From: [Steven Bell](#)
To: [A47-A11 Thickthorn](#)
Cc: [Jonathan Rush](#); [Nikki Fonseka](#)
Subject: Application by National Highways Limited ("the Applicant") for an Order granting Development Consent for the A47/ A11 Thickthorn Junction [BIRKETTS-LEGAL.FID9234081]
Date: 31 August 2022 12:18:26
Attachments: [Written Representation Mr & Mrs Thompson with plans.PDF](#)

**APPLICATION BY HIGHWAYS ENGLAND FOR AN ORDER GRANTING DEVELOPMENT
CONSENT FOR THE A47/A11 THICKTHORN JUNCTION**

MR AND MRS THOMPSON – THE SYCAMORES

WRITTEN REPRESENTATION

Drawing Title:
**CROWN LAND PLANS
REGULATION 5(2)(n)
SHEET 3 OF 7**

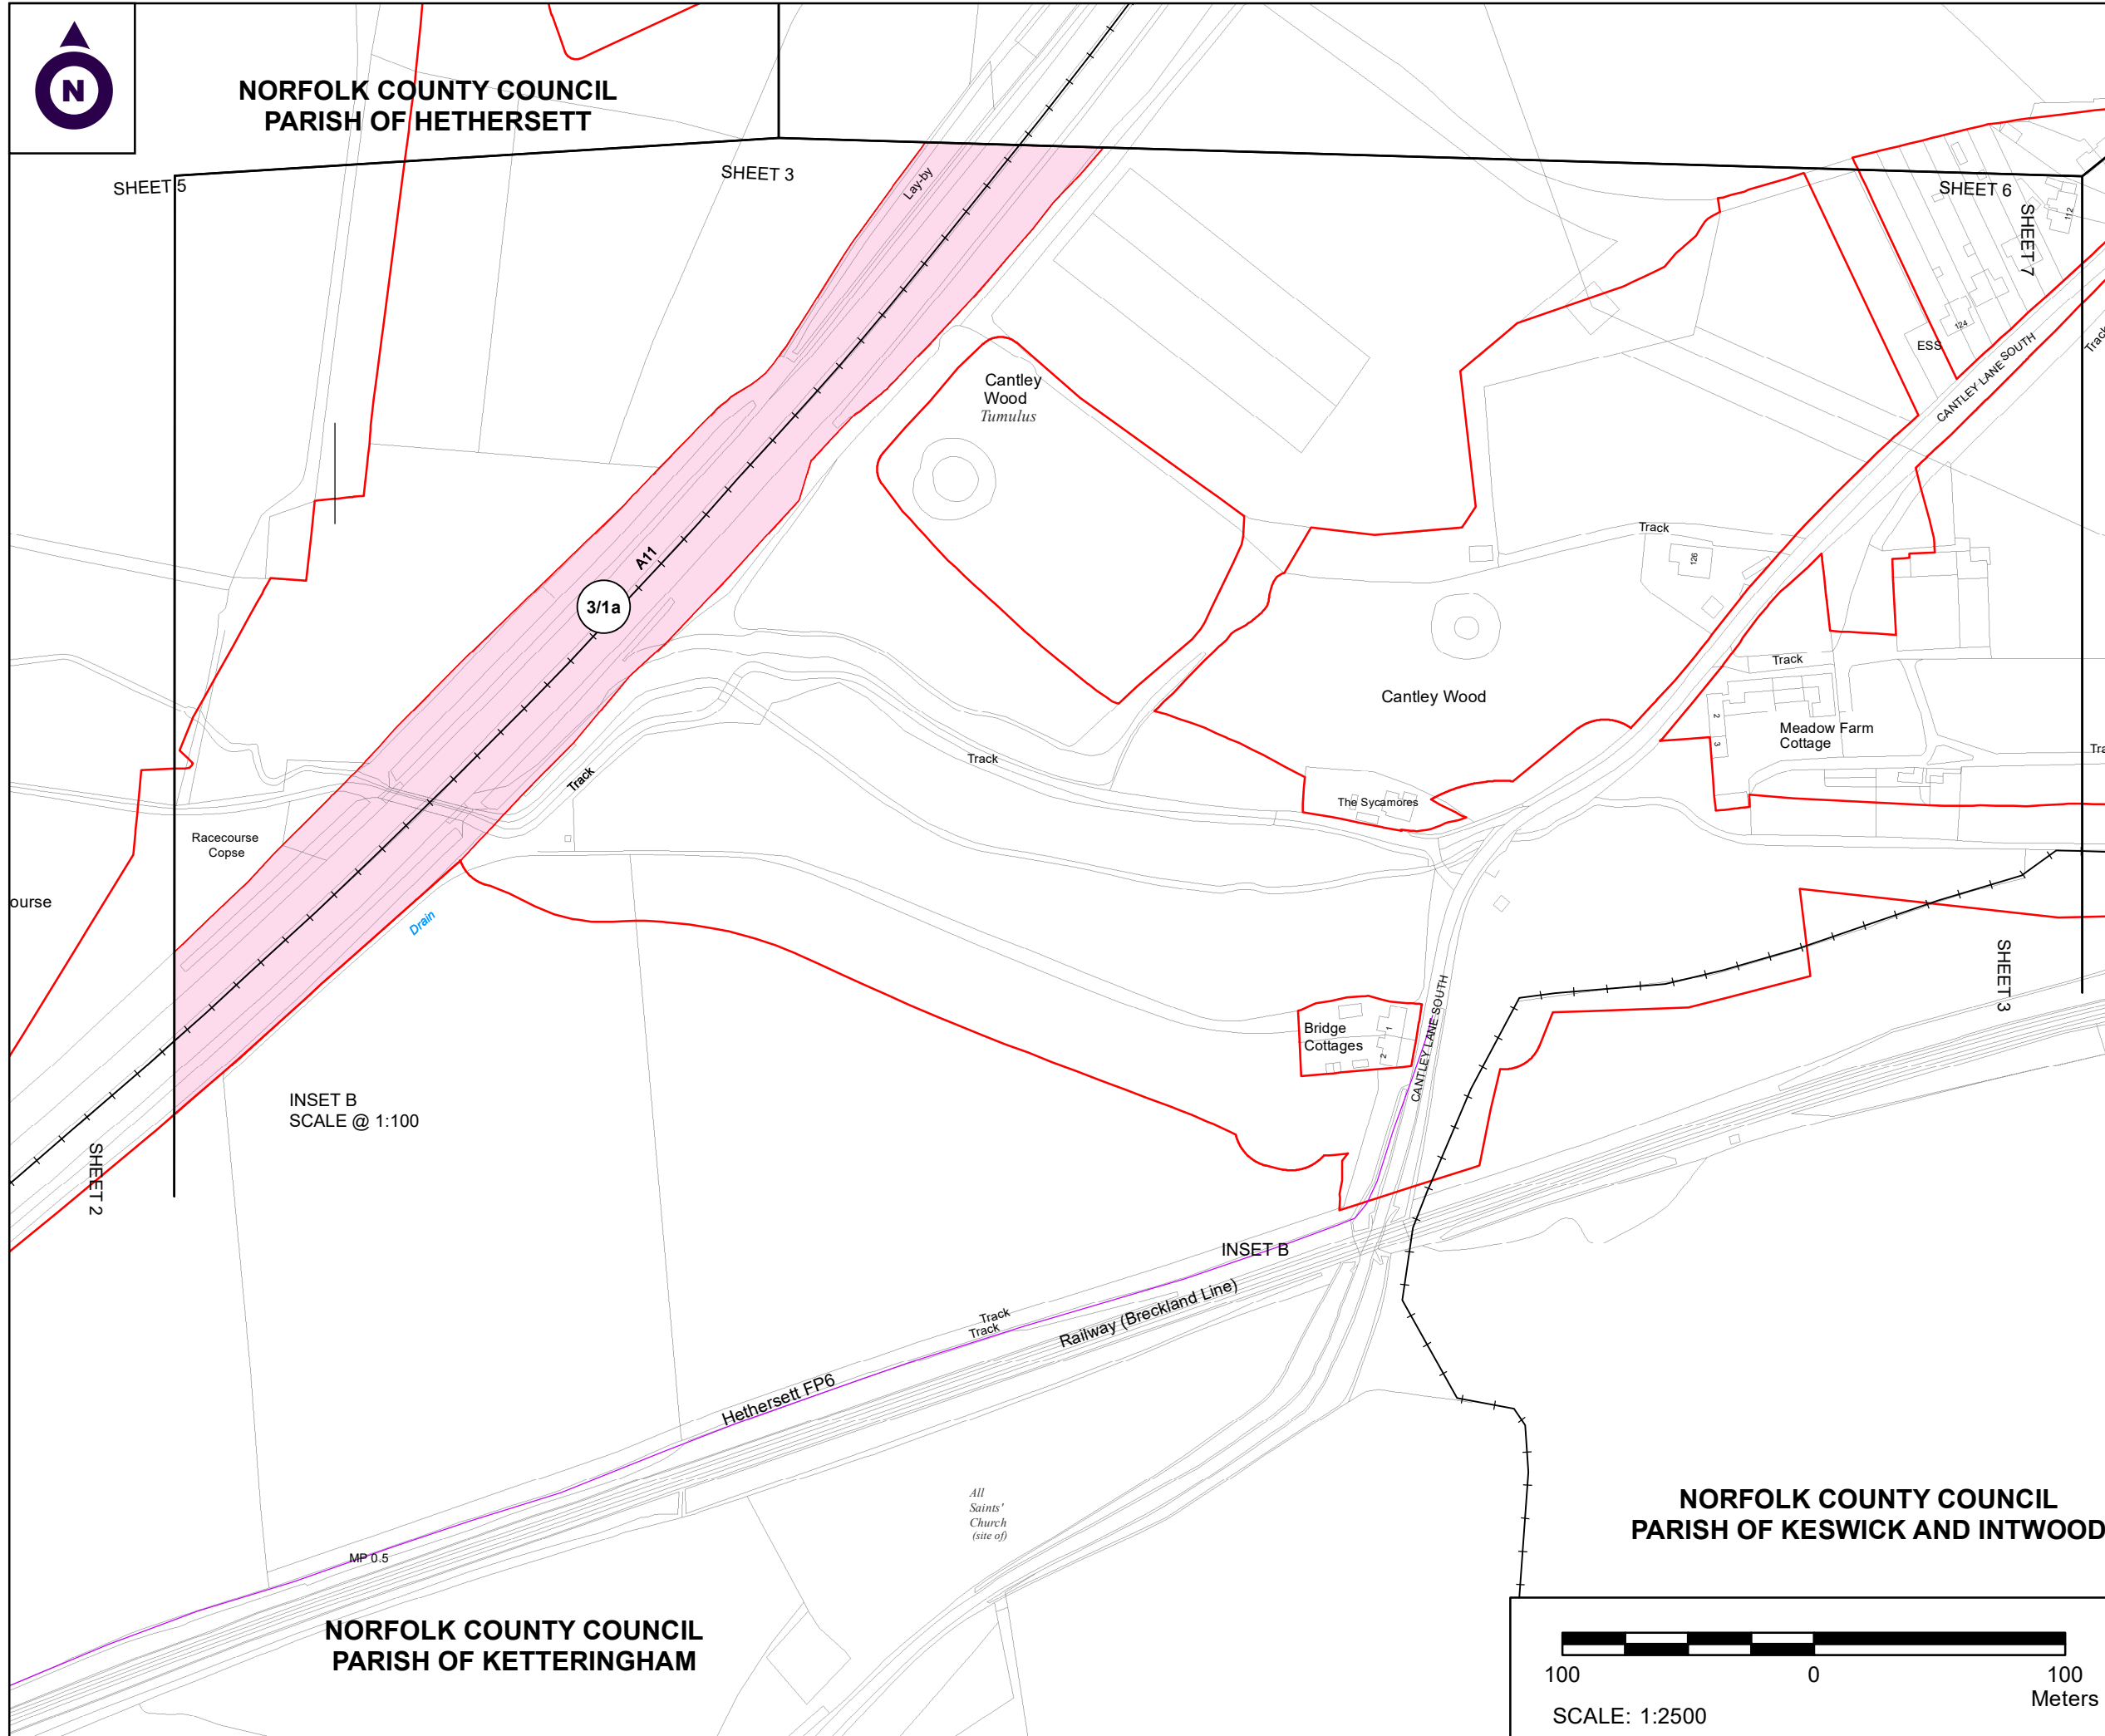
- 5.1 The areas of land adjoining the Sycamores to be acquired permanently and temporarily are shown on the Land Plans (Sheet 3) HE551492- GTY-LLO-000-DR-BL-30003 and marked 3/3d, 3/3h,3/3g. The Thompsons currently access the Sycamores over parcels 3/3d, 3/6d, 3/3h. The existing highway forms parcel 3/6c.

- 5.3 Parcel 3/3h is to be acquired temporarily. Once returned to the Trust there will be no direct access to the land acquired by Highways England and the adjoining highway. It is therefore essential that where land is returned to the Trust it is subject to appropriate rights of way and easements for services in favour of the Sycamores.

- 5.4 From discussions with Highways England it is understood that part of Parcel 3/3d directly adjoining the Sycamores which is to be acquired permanently, including the new access to the Sycamores, will likely be handed back to the Trust. Again it is therefore essential that any land returned to the Trust is subject to appropriate rights of way and easements for services in favour of the Sycamores.

PROPOSED EXTENDED ACCESS

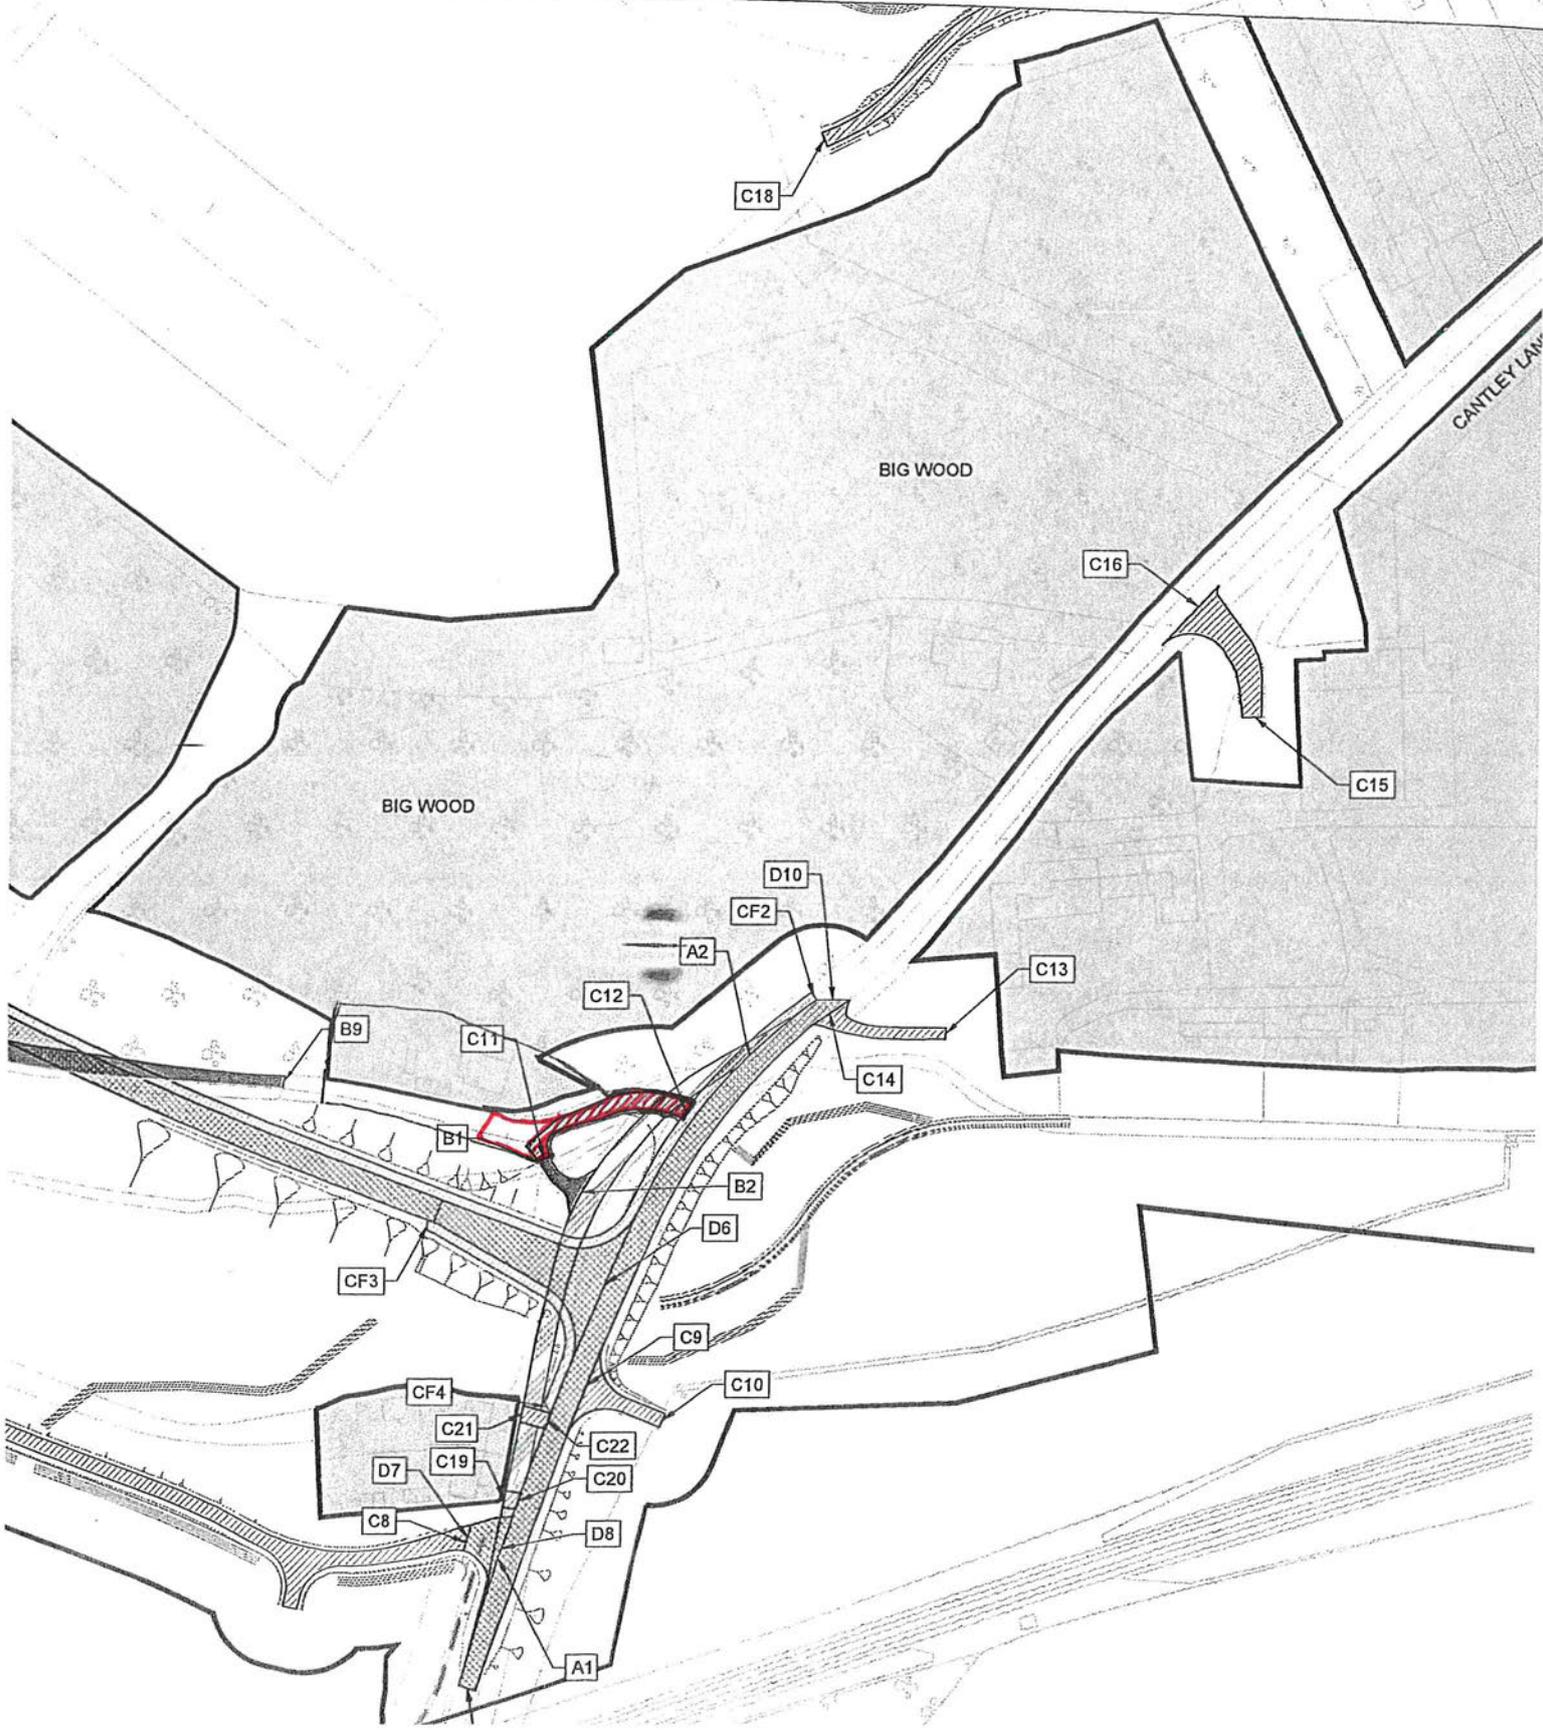
- 3.2.1 The extent of the new access is insufficient to allow access and egress for tanker deliveries of oil required to heat the Sycamores. The Thompsons have proposed an extended access. This is shown indicatively on the plan attached at Appendix 1 and marked "Proposed Extended Access". We request that the Works Plans and Access Plans are updated accordingly.

LAND BETWEEN PROPERTY AND HIGHWAY

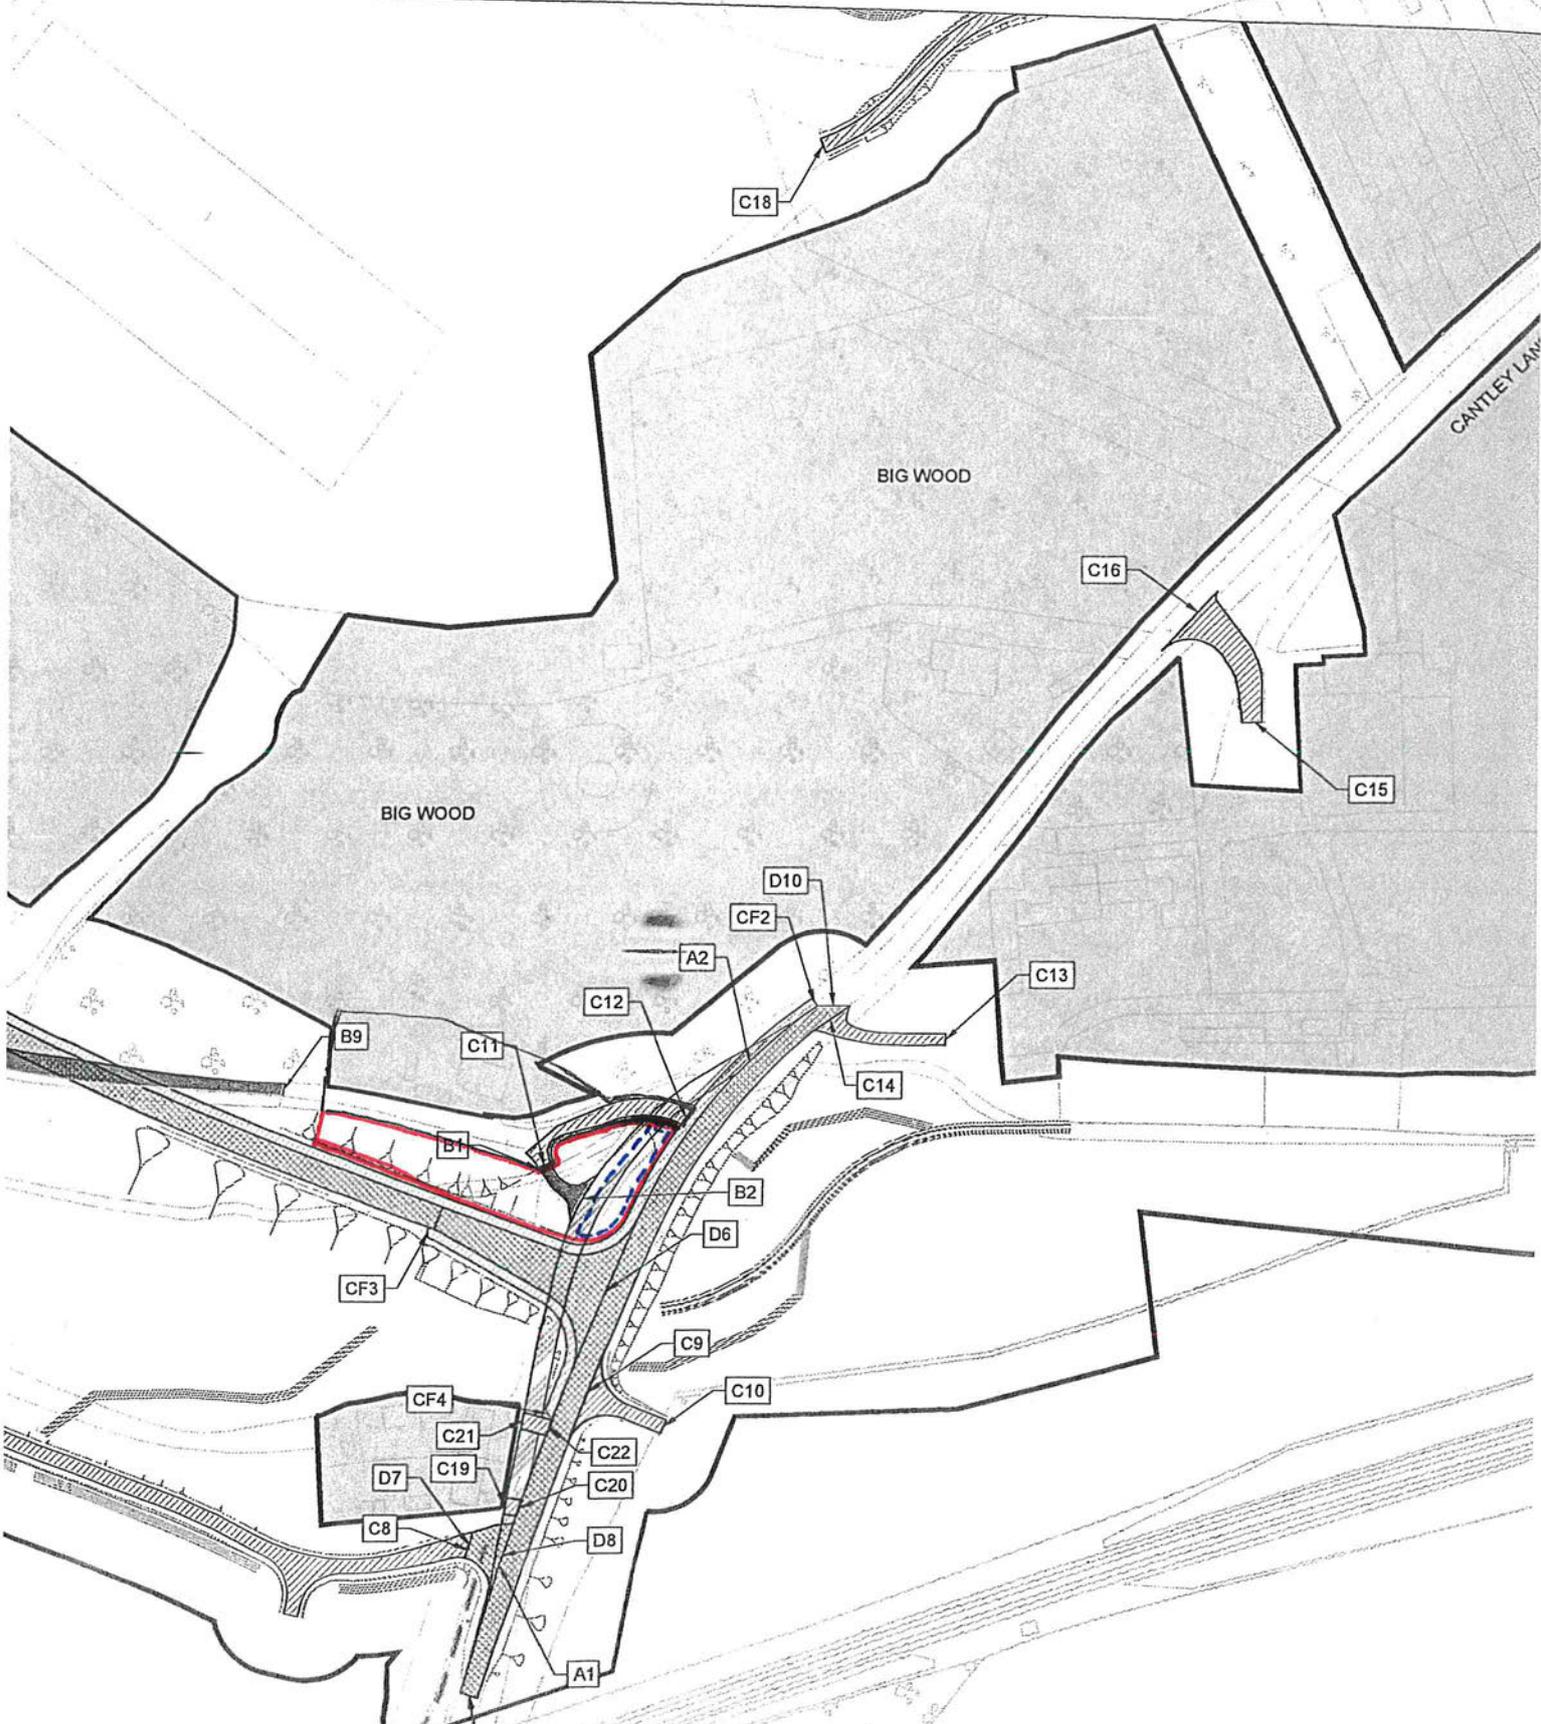
- 5.5 The Scheme will result in the realignment of Cantley Lane South to the south east into parcel 3/7a. The highway where it adjoins the existing access to the Sycamores will be stopped up. From discussions with Highways England it is possible that some or all of this land will be returned to the land owners. This will result in an area of land being returned to the owner of the land opposite based on the legal presumption of ownership to the centre line of the highway. This land would then be bound by highway and land owned by the Trust and would result in

an unmaintained area of land. The affected area is shown indicatively on the plan attached at Appendix 2 and marked “land between property and highway” by a blue broken line.

- 5.6 Also shown on the plan at Appendix 2 is an area of land edged red. Highways England have indicated that all or some of this land will be returned to the Trust along with the land shown coloured pink on the plan attached at Appendix 3 and marked “Proposed land to be transferred”. If returned this land would be bounded by the new link road and the Sycamores.

- 5.7 The Thompsons wish to ensure that all of the land marked by a blue broken line and so much of the land edged red on the plan at Appendix 2 as is necessary for mitigation measures is retained by Highways England and dedicated as highway. As detailed at 6.1 below the Thompsons wish to ensure appropriate noise mitigation and light barriers are installed in this area to reduce the impact of the Scheme on the Sycamores.
